From: Amanda Scholes on behalf of Planning.Responses
Sent: 08 February 2018 08:39
To: Planning.Scanning
Subject: FW: LU/7/18/DOC - Land adjacent to Shell Garage, Worthing Road, Littlehampton - Condition 4, SW Drainage

From: Paul Cann
Sent: 07 February 2018 14:19
To: Ross Leal
Subject: RE: LU/7/18/DOC - Land adjacent to Shell Garage, Worthing Road, Littlehampton - Condition 4, SW Drainage

Please therefore, see my comments below on their proposed scheme;

Engineering Layout

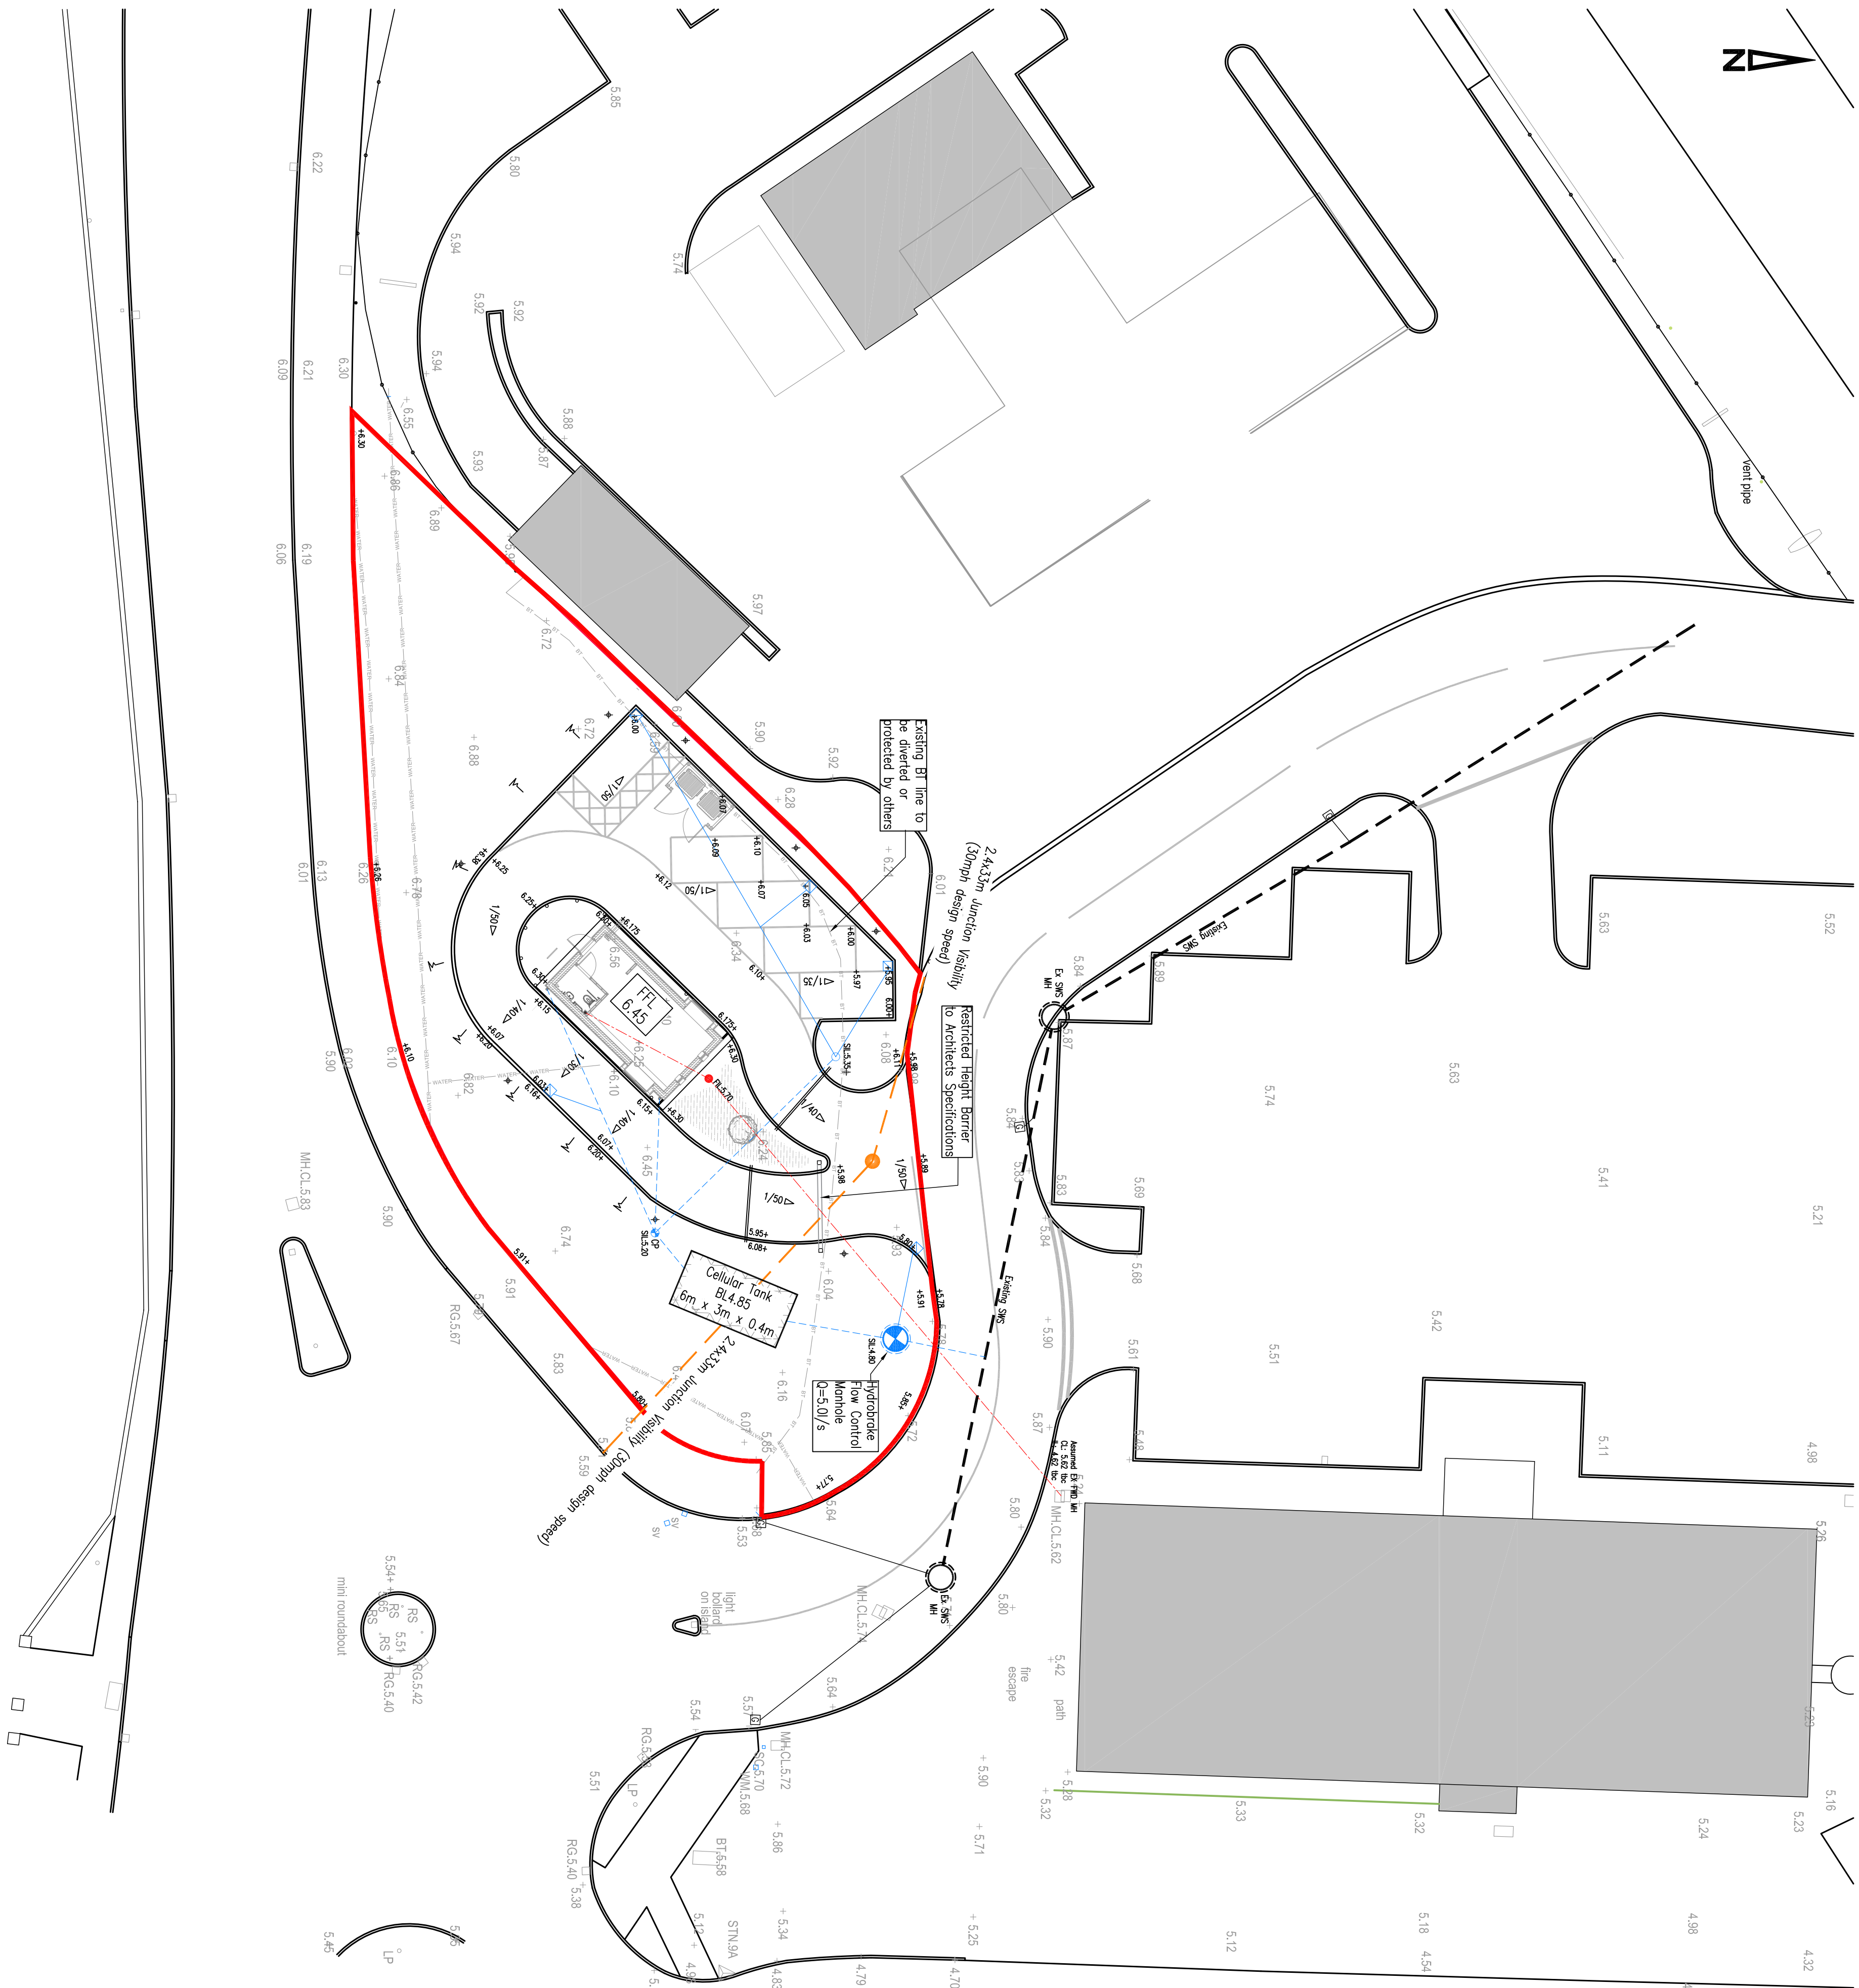
1. Confirm where the existing surface water drainage system discharges too. Presumably, this is the 'bodyshop' lake?
2. Specify more details of the existing pipe being connected to ie. diameter/levels.

3. Where connecting to the existing pipe, the connection will need to be made using an oblique junction with 'flexseal' or similar approved couplings. The connecting pipe will need to be positioned at 10 or 2 o'clock, assuming the top of the existing pipe is 12 o'clock.

4. Specify inlet and outlet levels for storage tank and incoming pipe diameter.
5. Tank outlet pipe diameter – increase to 150mm.
6. Provide catchpit manhole details.

10. Whilst infiltration is negligible, specify a permeable geotextile membrane wrapping to the crates to make use of any potential infiltration. The current coarse sand surround should be replaced with larger granular material ie. 20mm clean stone.

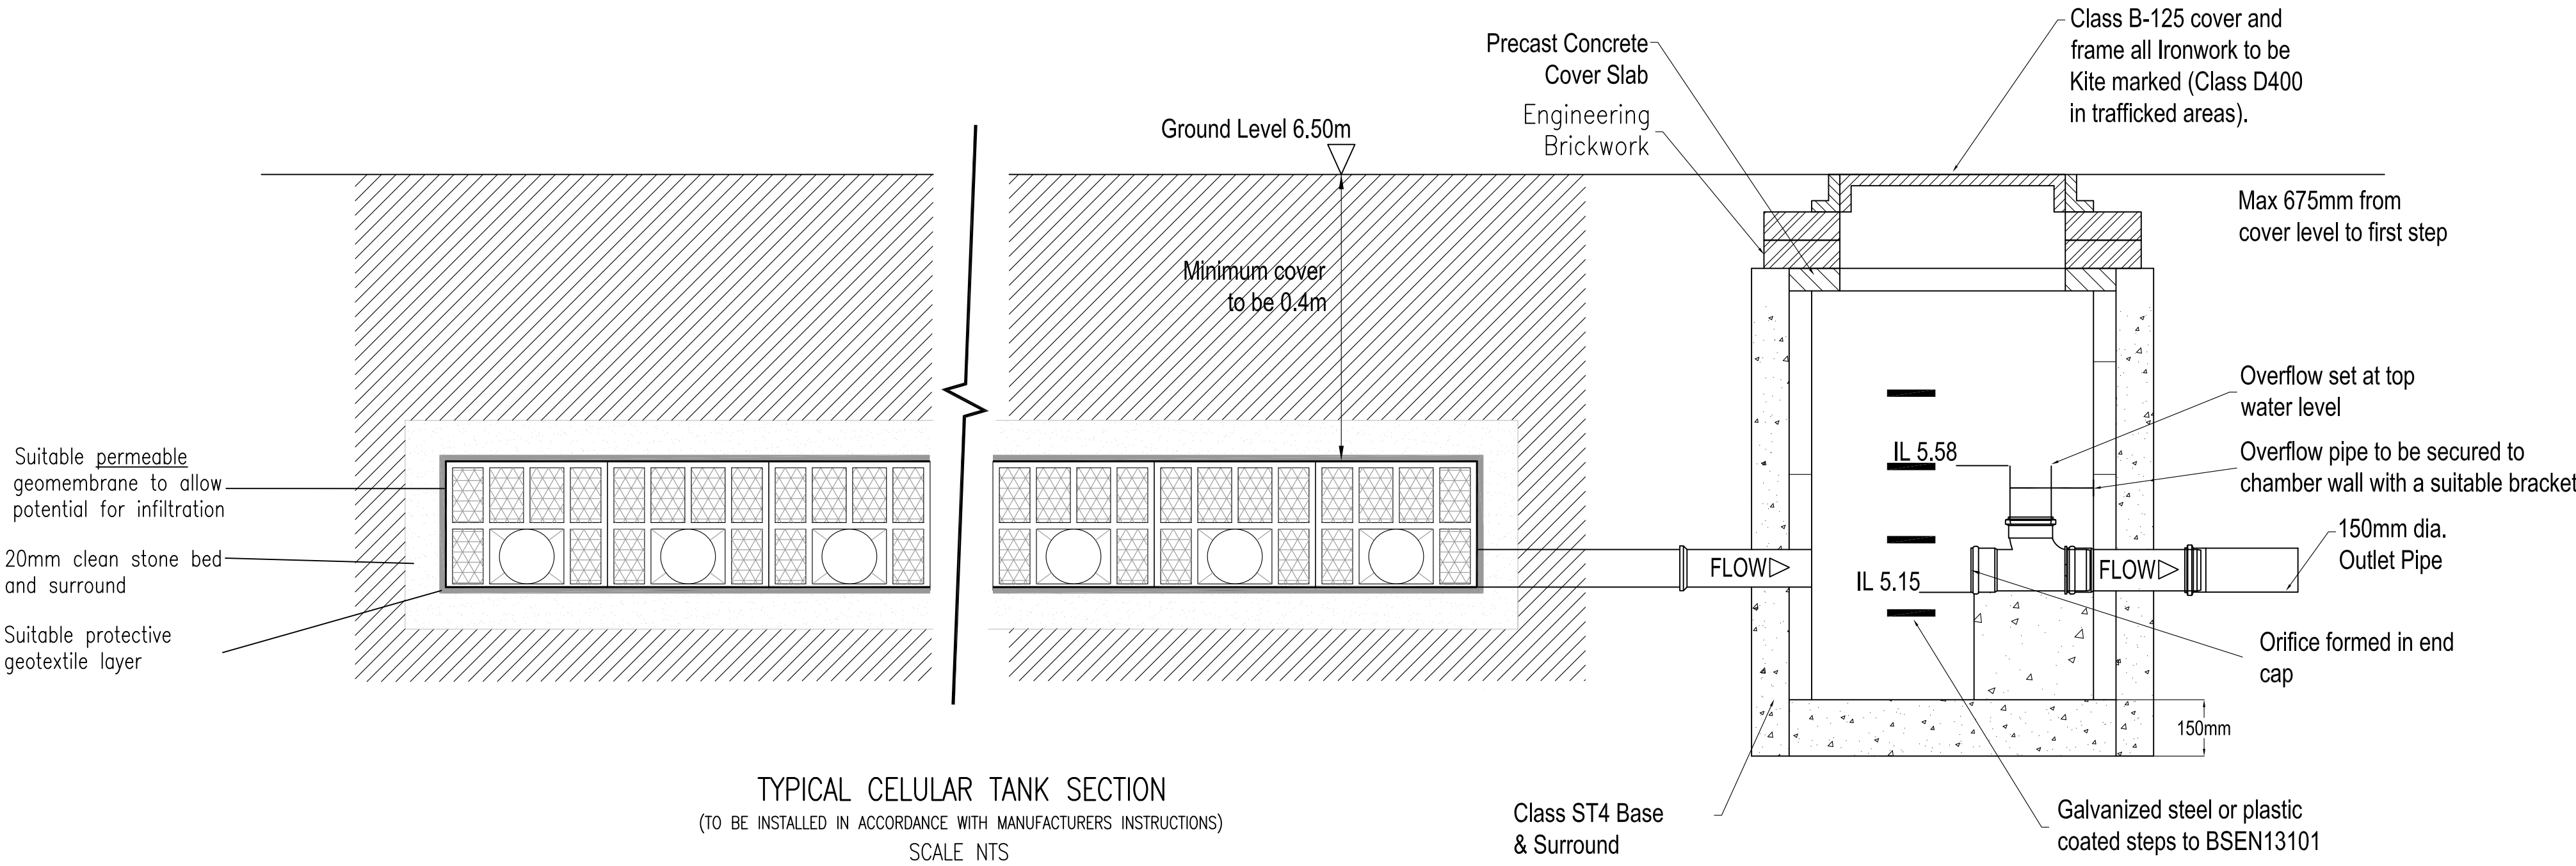
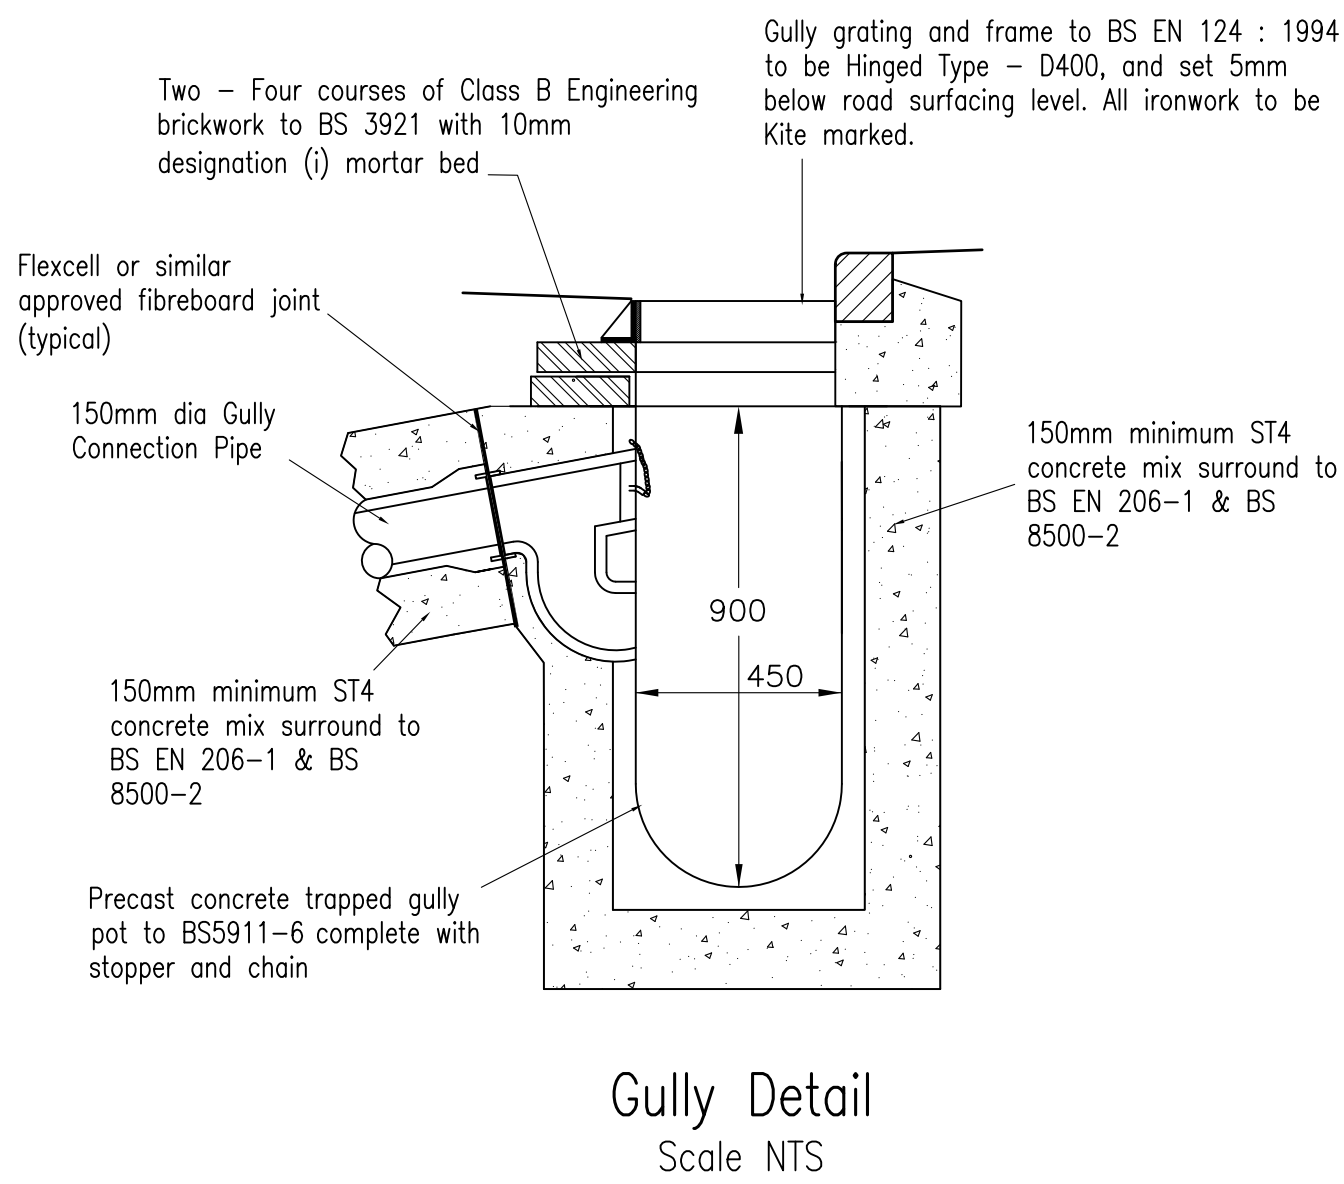
7. Provide hydrobrake technical details from manufacturer.
8. Hydrobrake manhole to incorporate step rungs and bypass door/wire.
9. Microdrainage calculations are required to prove that the 1 in 100 year storm event + 30% allowance for climate change can be accommodated within the system.
